CITY OF ALBUQUERQUE

**Re: 25 Hotel Circle NE
Traffic Impact Study, Final
HT#K21D015, Dated March 2021**

The subject Traffic Impact Study for the 25 Hotel Circle NE, Ramada Hotel Apartment Conversion, sealed 3/23/2021 has been accepted and approved by the Transportation Development Section.

Figure 2. Site Plan

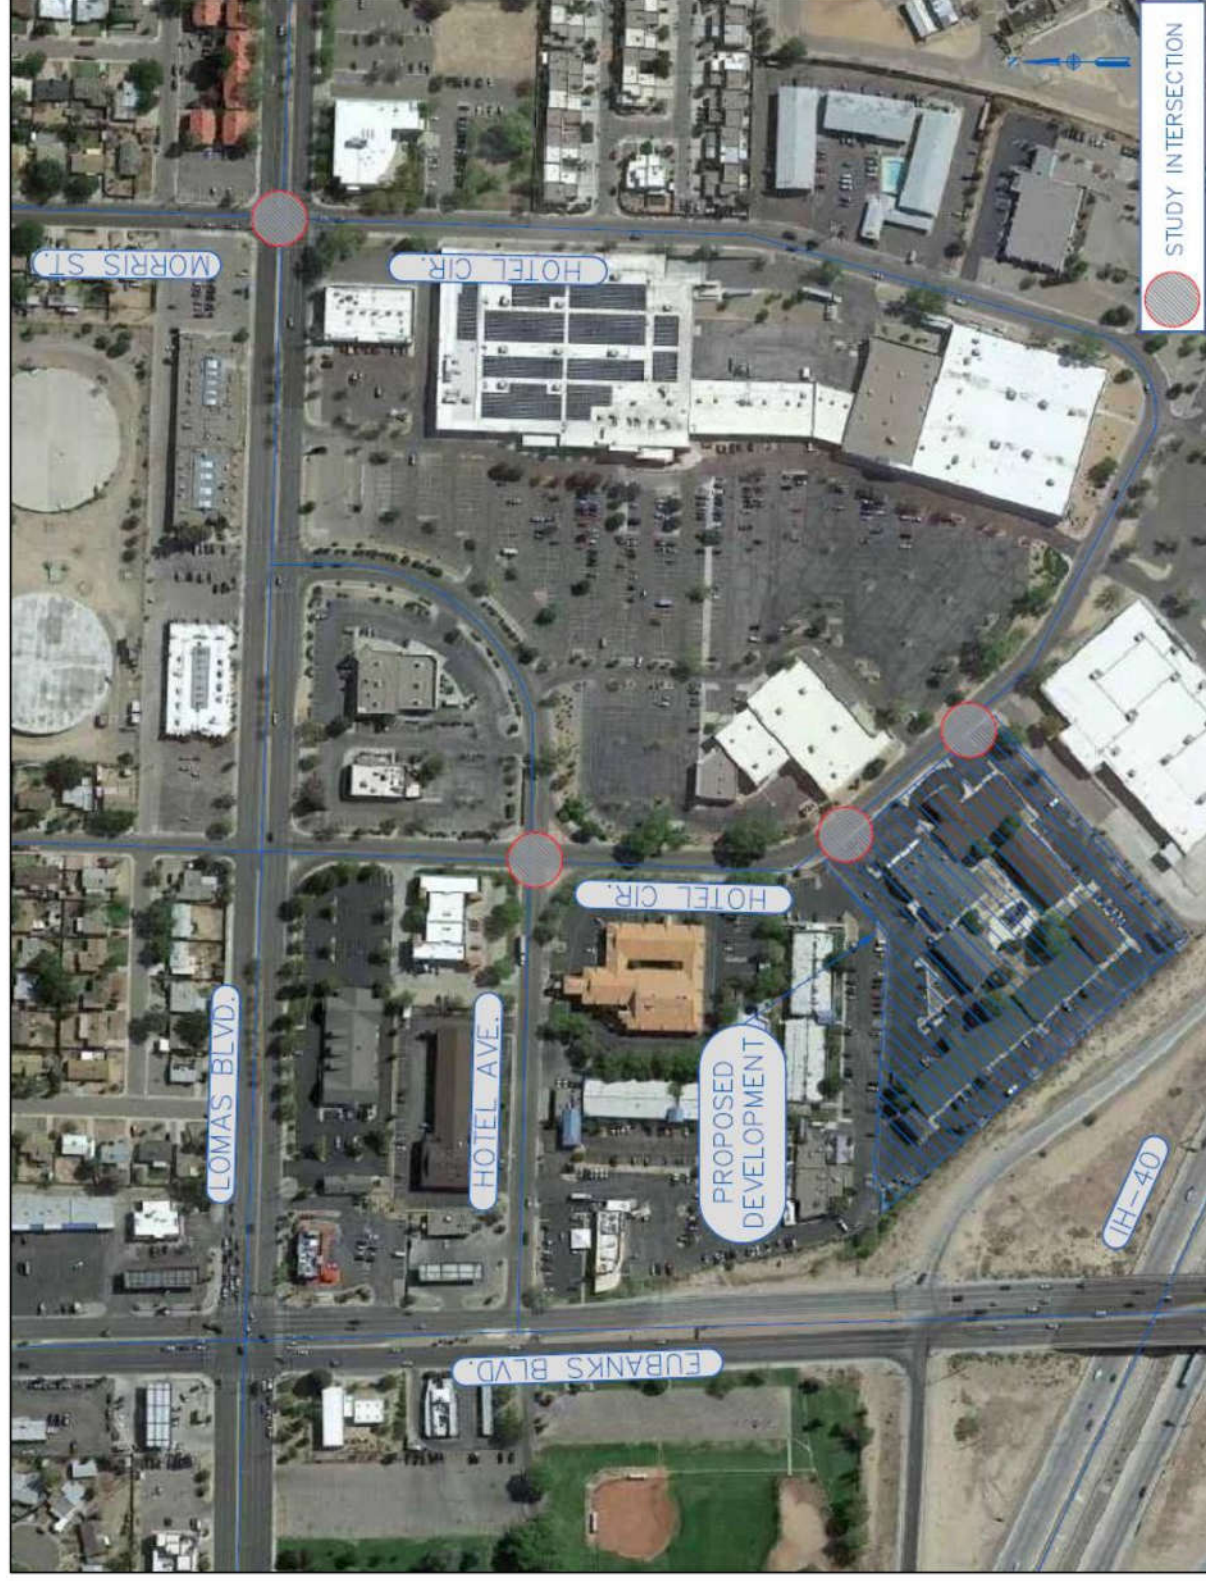
1. Restripe the left-turn lane centerline for the northbound approach on Hotel Circle NE at Loma Blvd NE. Lengthen the northbound left turn lane to be 150 feet long plus the transition or as far as possible without encroaching on the driveway to the south.
2. CABQ DPM compliance requires that the west access driveway be separated from currently shared driveway. It is recommended to reconstruct the west access to be reduced to 24 feet wide and have curb return radius of 25 feet. The driveway should be five feet or greater from the property line.
